From: Tom Errico <thomas.errico@tylin.com>
To: Helen Donaldson <HCD@portlandmaine.gov>
CC: David Margolis-Pineo <DMP@portlandmaine.gov>, Katherine Earley <KAS@portlandmaine.gov>, Jeff Tarling <JST@portlandmaine.gov>, "JeremiahBartlett" <JBartlett@portlandmaine.gov>
Date: 11/5/2015 11:23 AM
Subject: 3 Pleasant Avenue - Final Traffic Comments

Memo To: Nell Donaldson
Barbara Barhydt
From: David Margolis-Pineo
Re: Review Comments for 3 Pleasant Ave. – 2015-102

To: FILE
From: Nell Donaldson
Subject: Application ID: 2015-102
Date: 11/5/2015

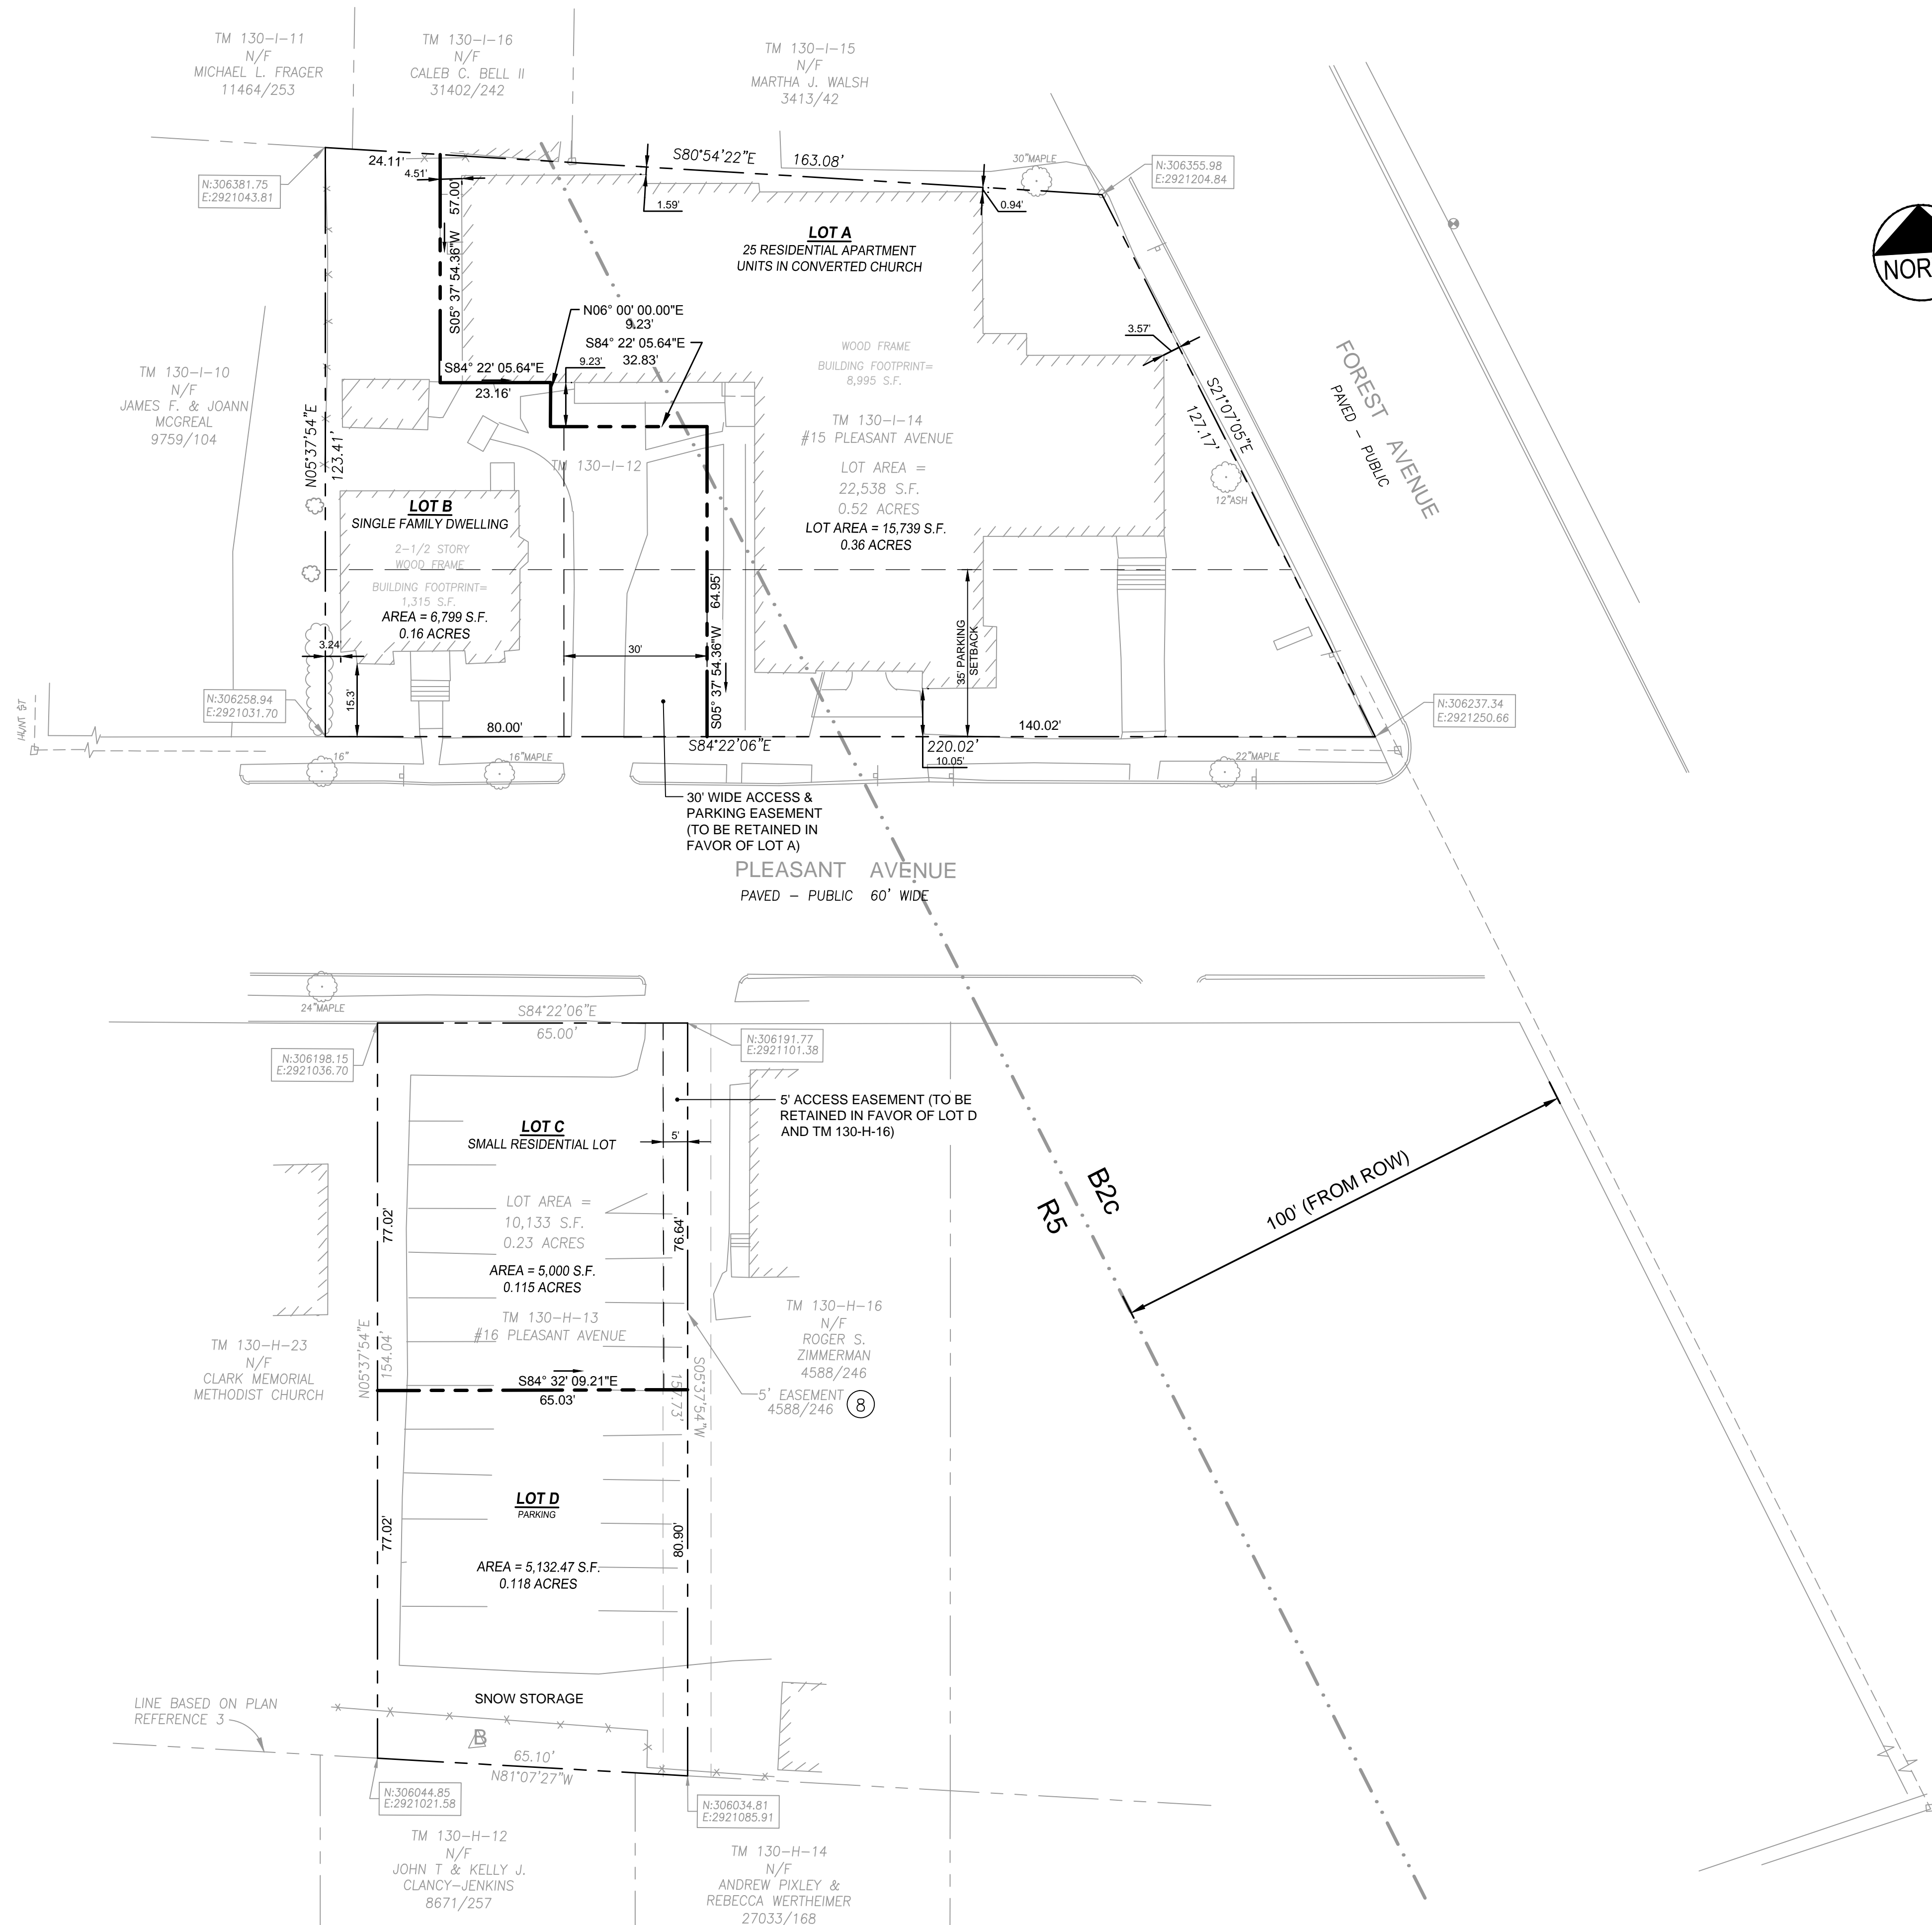
1. This is a Subdivision Plan and needs a Professional Land Surveyor's Seal. This is State Law.
2. They need to show property corners to set. This was requested at the last review.
3. Proposed Easement for Transit Shelter.
 - Needs to state "to be conveyed to the City of Portland".
 - Needs bearings and distances to define the area.
 - Needs to meet dimensional requirements of METRO bus shelters, the concrete pad,
 - and area around it to allow for maintenance.

4. Easements on the south side of Pleasant Avenue need to be clearer and state who is benefitted by them.

5. Since all the information on the ALTA/ACSM Land Title Survey is not included there needs to be a reference to the Title Survey and the Title Survey should be recorded.

They addressed all five of my comments from 10/22/15, and the easements are clear, as well as the property corners to be set.

I notice they changed the boundary line between Lots A and B.

PROJECT PLEASANT AVENUE CHURCH RE-DEVELOPMENT			DRAWN: PBF DESIGNED: ADJ CHECKED: ADJ FILE NAME: SP-M167-SP
SHEET TITLE SITE LAYOUT PLAN			
CLIENT HARDY POND DEVELOPMENT COMPANY, LLC		P.E. ANDREW D. JOHNSTON LIC. # 9394	SHEET C-3.0
1 06.17.15 PRELIMINARY CITY SUBMISSION	REVISIONS

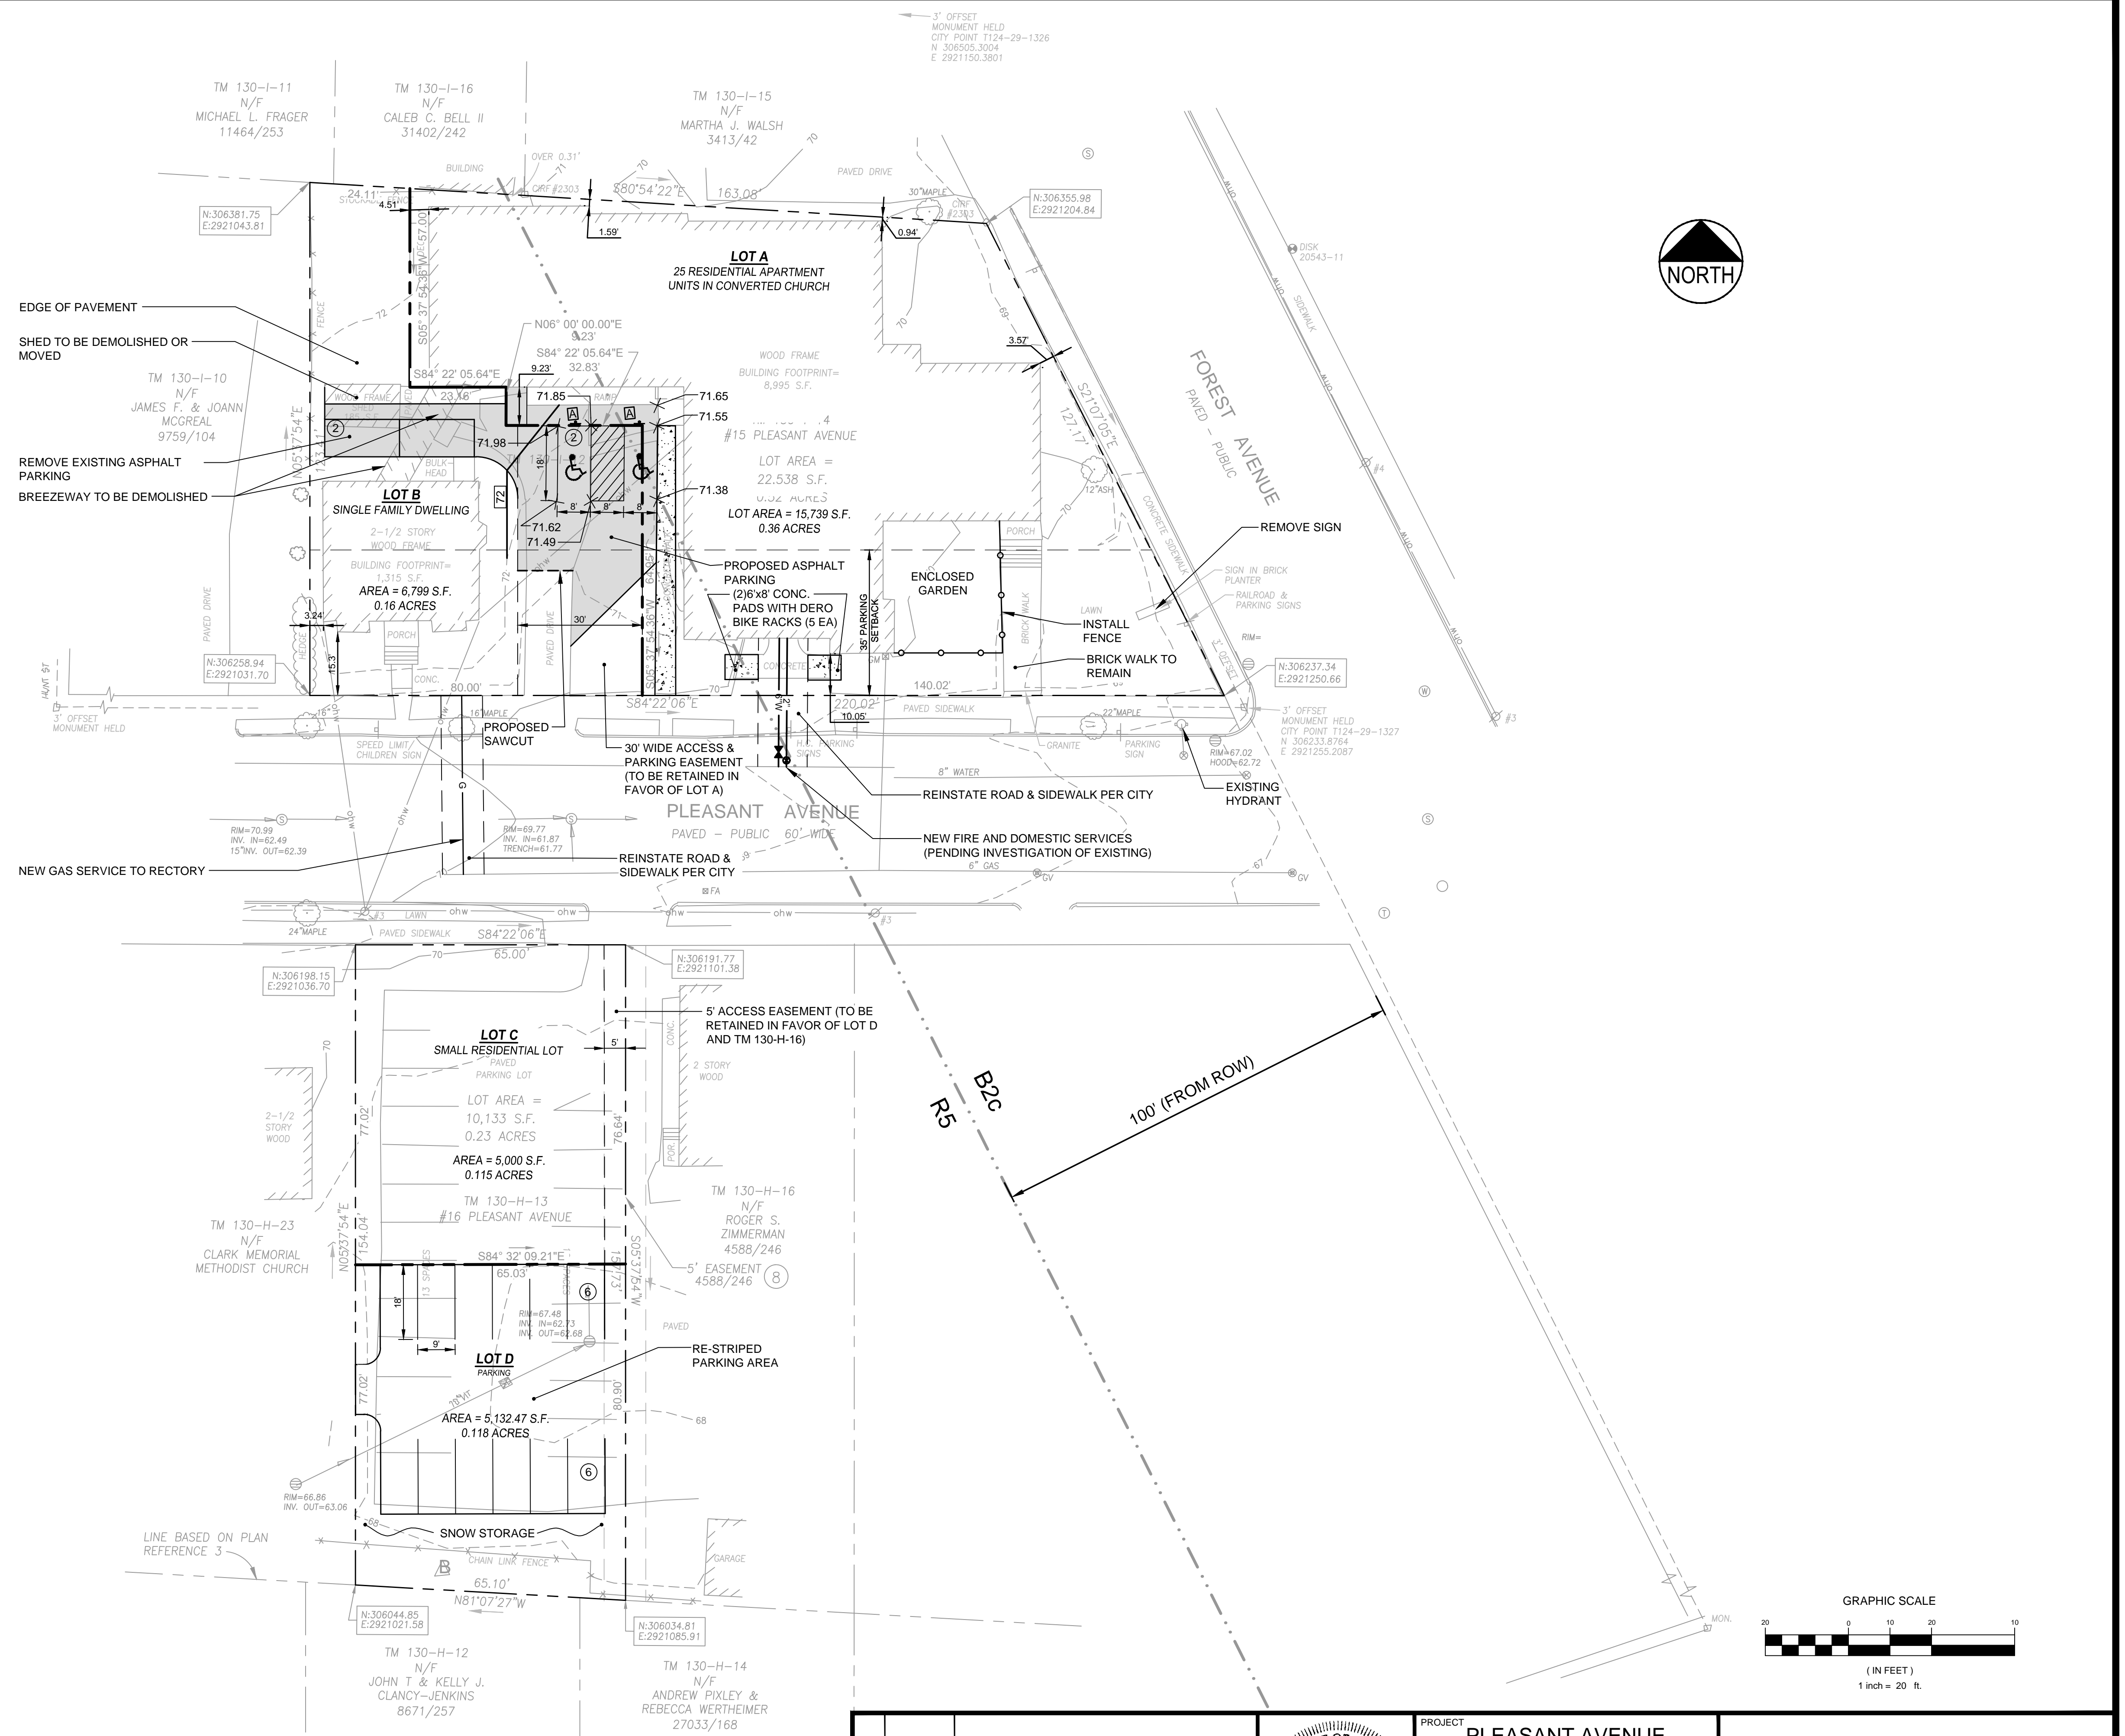
* I find the parking lot layout on the south side of Pleasant Avenue to be acceptable. With that, the applicant should provide dimensions for the driveway servicing the abutting residential property and provide information on winter maintenance agreements/responsibilities. I would note that encroachment into the driveway by project vehicles is possible, and accordingly delineation of parking spaces is important. Status: The applicant has revised the plan to account for this and noted working with the abutting owner regarding maintenance. I have no further comment.

* The parking area abutting the building is very tight and I'm not sure is workable. The applicant should explore the possibility of relocating one handicapped parking space to the main parking lot, thus creating a more space for vehicle circulation from the two abutting parking spaces (This would need to meet ADA regulations and must be confirmed). I would be supportive of providing additional compact size parking spaces to allow for the target 25 parking spaces. Status: The applicant has agreed to providing two stacked parking spaces for the single family use and therefore I have no further comment.

After further looking at the curb cut and driveway for emergency access off Pleasant Ave. it appears very narrow. Emergency access lanes must be minimum 20'.

After having discussions with Nell around the driveway and curbcut on Pleasant, the Fire Dept. will be okay with the proposed width of the driveway for emergency access. We discussed the possibility of moving one of the new proposed trees away from the driveway /curbcut to allow for better aerial ladder access to the upper floors of the apartment building.
